Australian Turf Club Royal Randwick Racecourse- Hotel Development Design Addendum Report

Prepared for the Australian Turf Club • September 2013

This report has been prepared in response to 'Key Points of Comments/Issues and Recommendations for Royal Randwick Racecourse – Hotel Development' prepared by GM Urban Design and Architecture Pty Ltd on behalf of the NSW Department of Planning and Infrastructure (DPI) dated February 2013 for SSD 5002-2011. The response and subsequent meeting on 19 February 2013 between the proponent and the DPI resulted in a number of design amendments contained within this addendum.

Design Modification

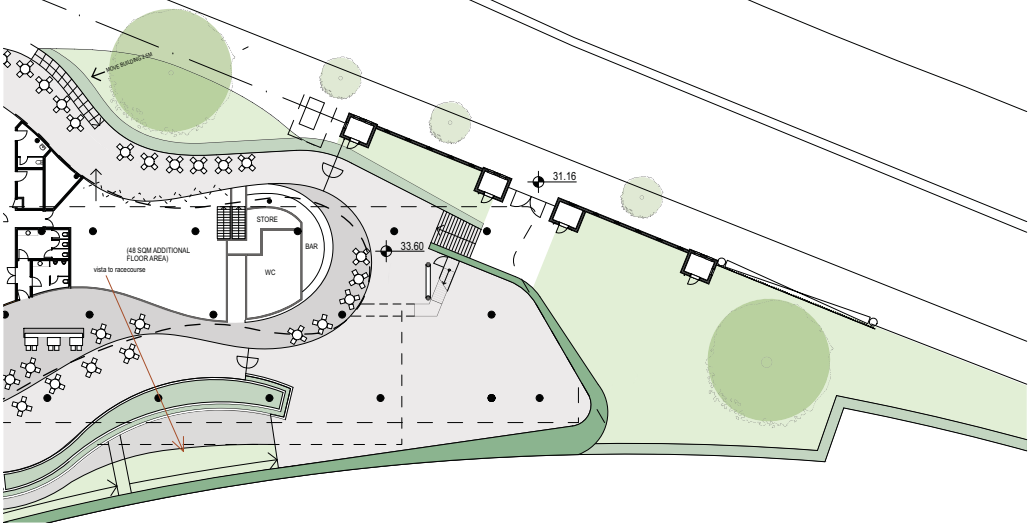
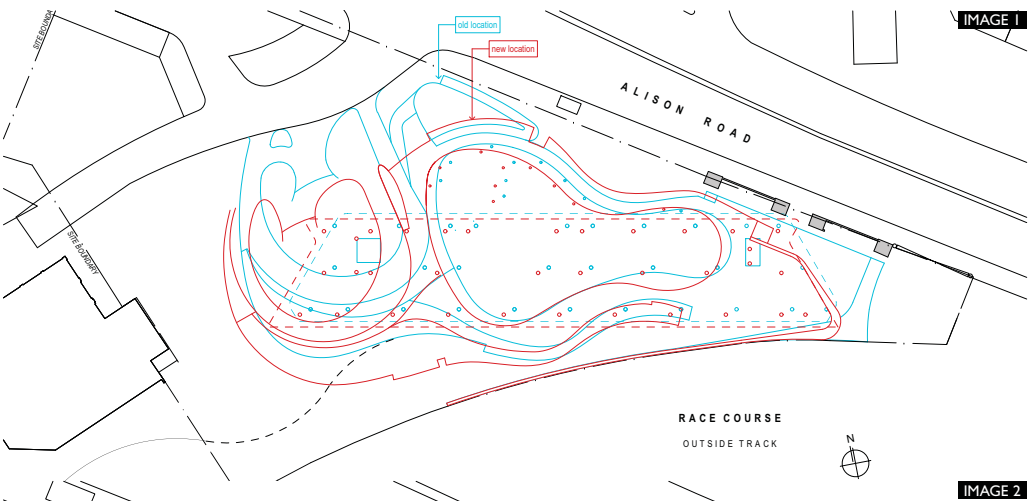
- Relocating the building 2m to the west and 1m to the south of the previously proposed building footprint location away from the existing heritage gates fronting Alison Road.

- The modifications do not result in any additional increased height and scale to the building, and it is acknowledged that the proposed building height is justified by the precedent of the TAFE building and the new grandstand building at RRR.
- The relocation of the building 2m west and 1m south of the existing heritage gates improves the relationship between the building and the heritage gates and results in an improved relationship between the two structures.
